From: Anita Gardner <Anita.Gardner@arun.gov.uk>
Sent: 25 February 2020 15:00
To: Planning.Responses <Planning.Responses@arun.gov.uk>
Subject: FW: K/32/19/PL Little Deerswood

From: Anita Gardner <Anita.Gardner@arun.gov.uk>
Sent: 21 February 2020 16:17
[REDACTED]
Subject: K/32/19/PL Little Deerswood

1703 SK126
 Little Deerswood, Kingston Gorse
 South Elevation
 Scale 1:100

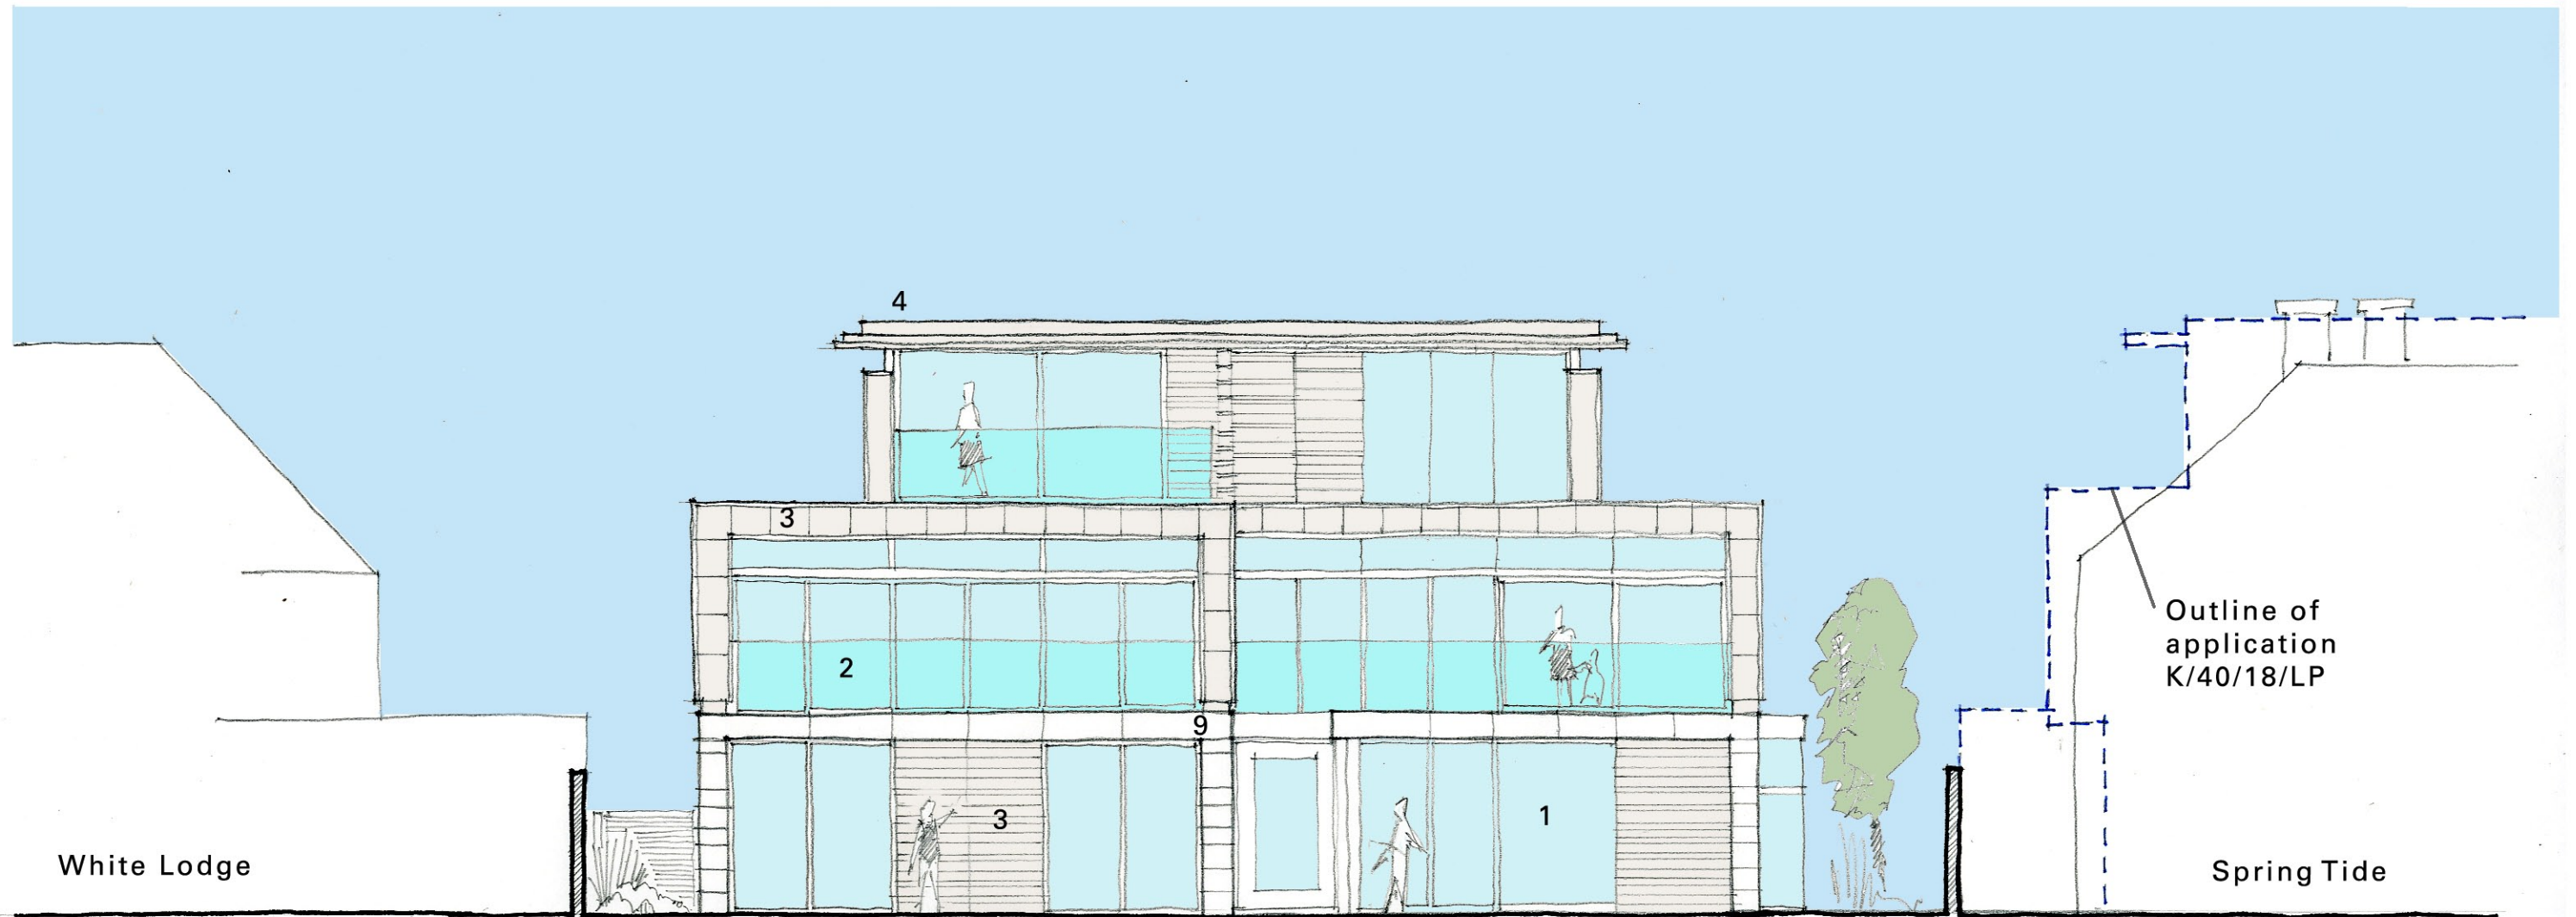
Dear Haydn,
Members have requested further details of the proposed materials. Can you let me have samples and photos of the same materials on other developments, particularly any within the local vicinity. I would appreciate receipt as soon as possible to enable consideration at Committee.

The both materials have been chosen for their longevity and weathering characteristic (requiring no maintenance) and that they are prominent in the area. Natural and reconstituted stone is used throughout the estate in different forms, random sandstone, dark slate, (Dolphins now Beach House), light grey High Water House, and recently approved Spring Tides scheme all on Gorse Ave. On this proposal we have chosen a lighter (white limestone) to match the white render of adjacent properties. As you know and a factor which should be taken into consideration is the amount of maintenance render requires and how unsightly it can become if not maintained, evident all the way along the sea front properties. Something we are trying to avoid here.

Again the zinc has been used extensively used and was given approval on the neighbouring Spring Tides project on the upper floor and roof. Other examples include, Dolphins, Bramble Down on Middle Way, Kingston Gorse and many along Coastal Road.

I will drop some samples of zinc and the type of reconstituted stone colour we are looking to use, at your office on Monday. However as you can understand there are many variations on stone and we would provide exact samples before construction. However happy to agree the sample now if that was required for approval and remove the condition which is sometimes helpful.
